Subject: 2021/93644 Erection and operation of grid-connected solar photovoltaic farm, with ancillary infrastructure and landscaping and biodiversity enhancements LOW FARM, WAKEFIELD ROAD, GRANGE MOOR, WAKEFIELD, WF4 4BB

Thank you for reconsulting Sport England in respect of the amended / additional details relating to the above planning application.

Drawing Infomation	
Scale	1:2500 @ A0
Stage	ISSUED FOR REVIEW
Drawing Name	Overall Layout
Drawing Number	B001
Designed By	Samuel Hogan
Sheet 1 of 1

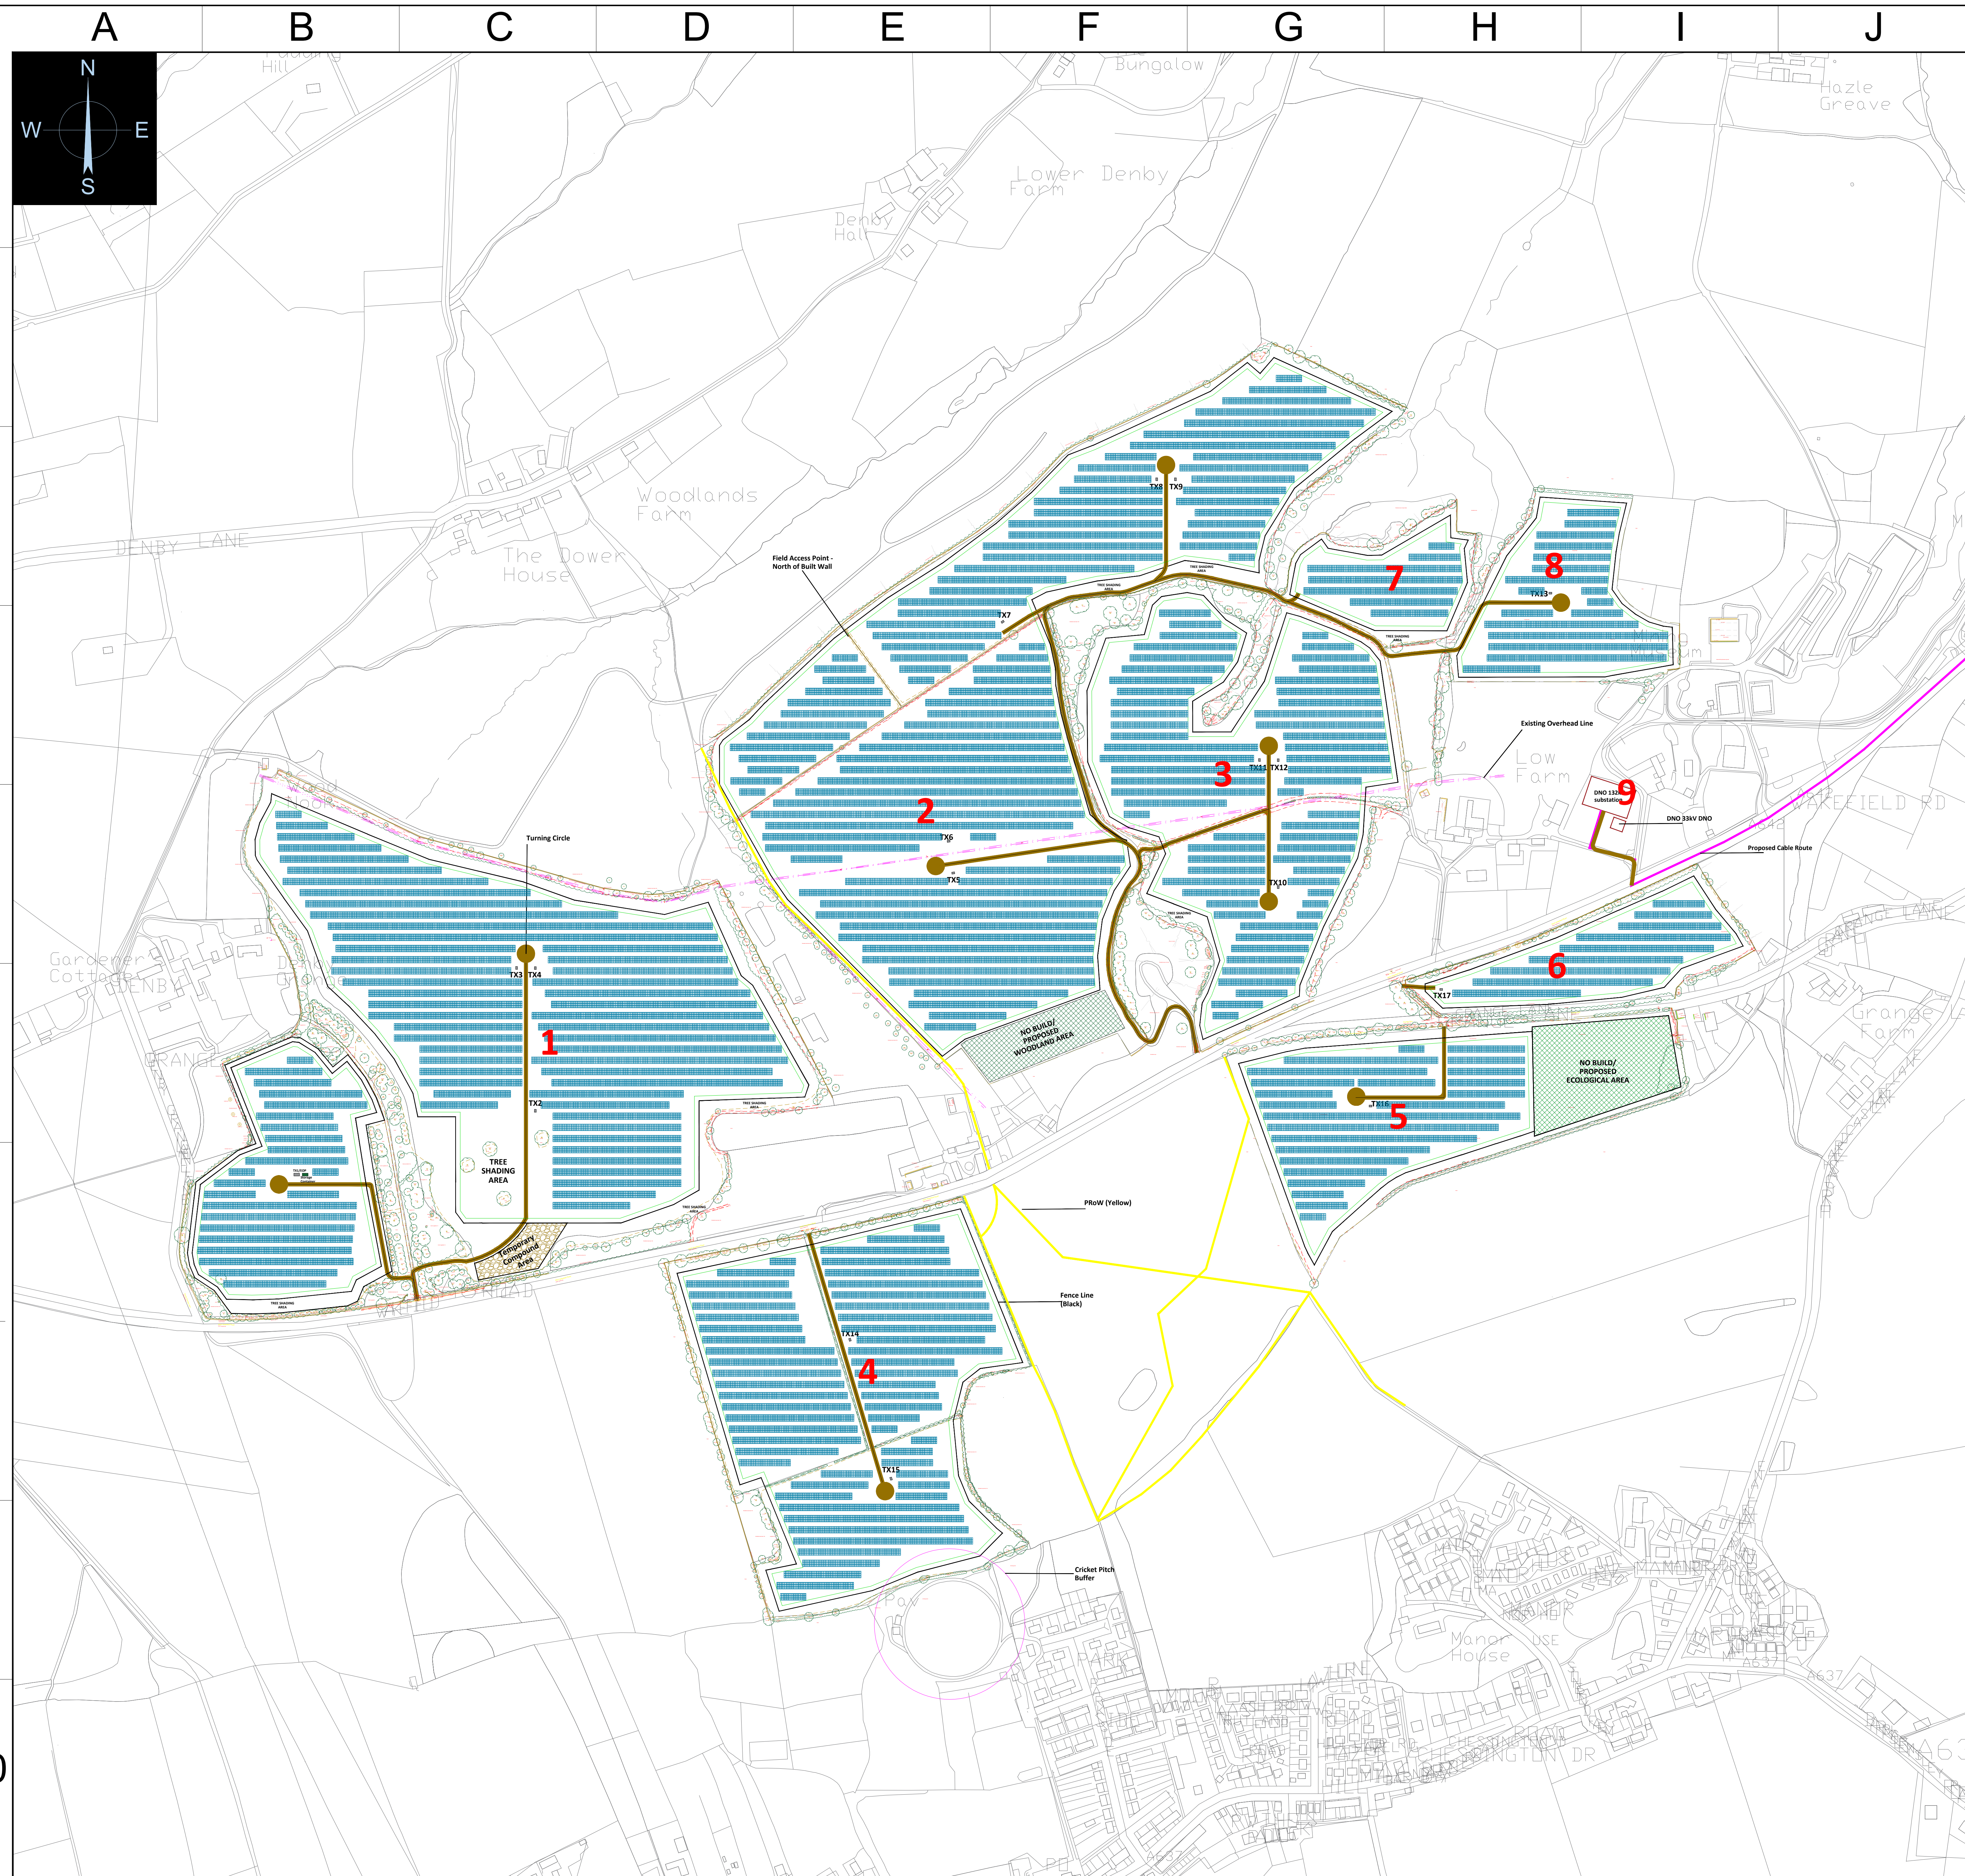
Sport England raised a statutory objection to the proposal as we were concerned that the close proximity of some of the photovoltaic panels to Flockton Cricket Club's ground might prejudice the club's future.

Block Plan Drawing no B001V3.5 shows that a cricket pitch buffer has been created so that none of the panels would lie within 80m of the cricket. Provided the approval is tied to this layout then Sport England is satisfied that the proposal will no longer prejudice the cricket ground. As such we wish to **withdraw our objection**.
